From: Michael Flory
Sent: Monday, August 31, 2015 8:27 AM
To: Lindsey Ozbolt
Subject: RE: VA-15-00001 Heric - Notice of Application

[VA-15-00001 Heric](#)

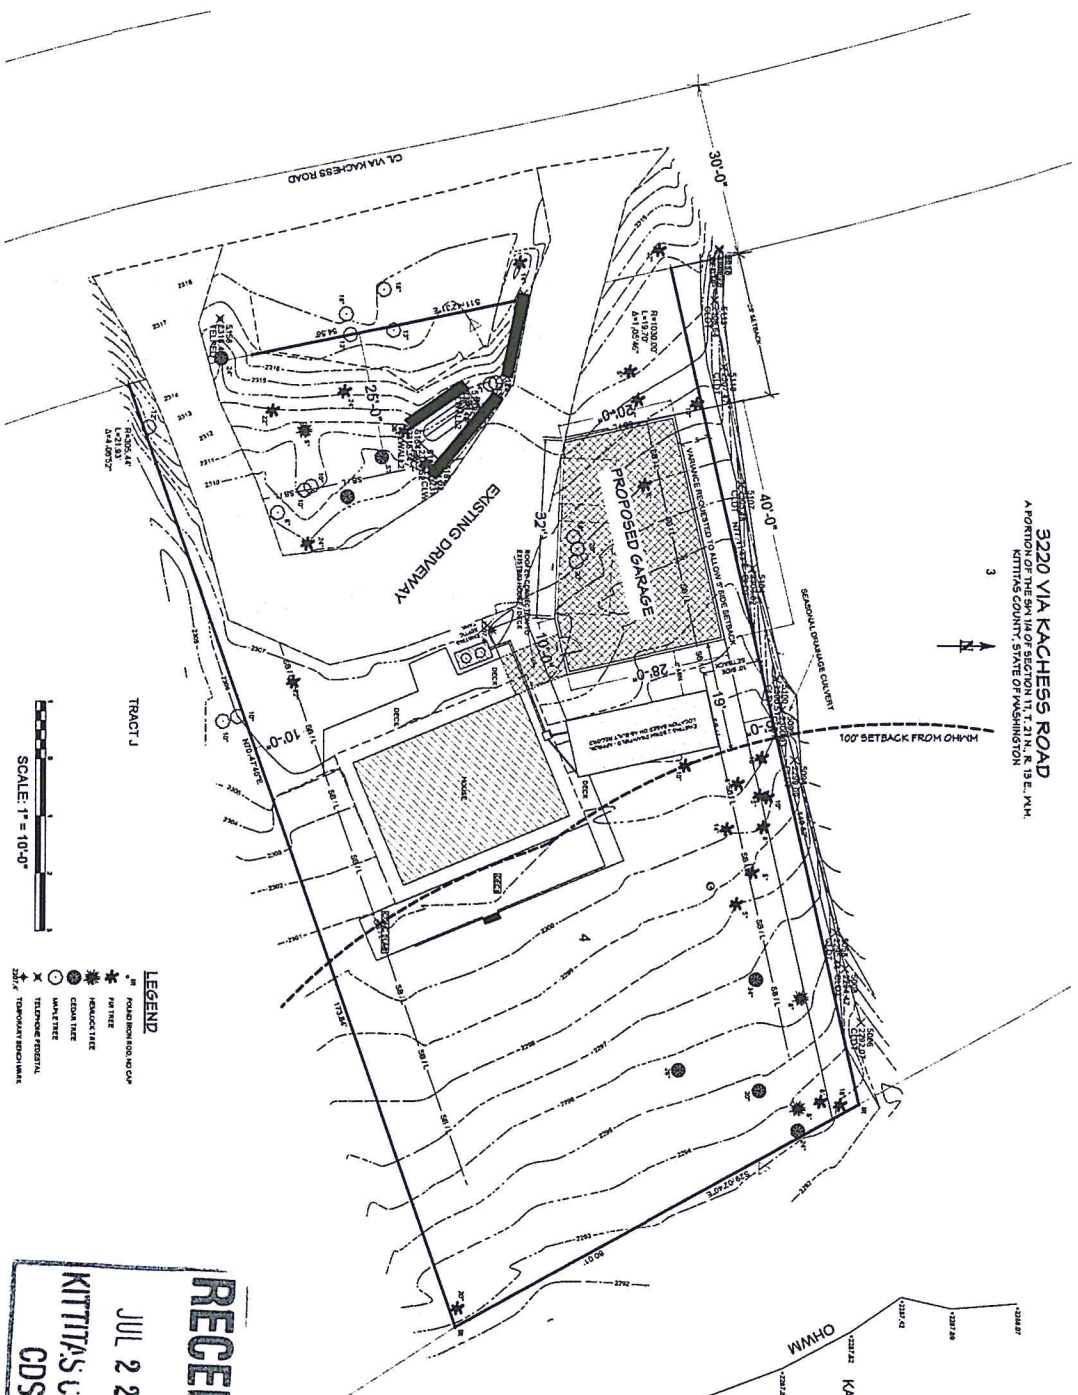
The proximity of the proposed garage and the location of the adjoining neighbor's structure could present snow buildup onto the neighboring lot.

If the garage roof slopes back towards the proposed variance side lot, CDS Building Dept. recommends against the variance due to the high snow load and potential impact to the neighboring property..

I am unable to determine the slope of the roof structure by the site plan and recommend a roof plan be submitted for review and further comment prior to determination of the variance.
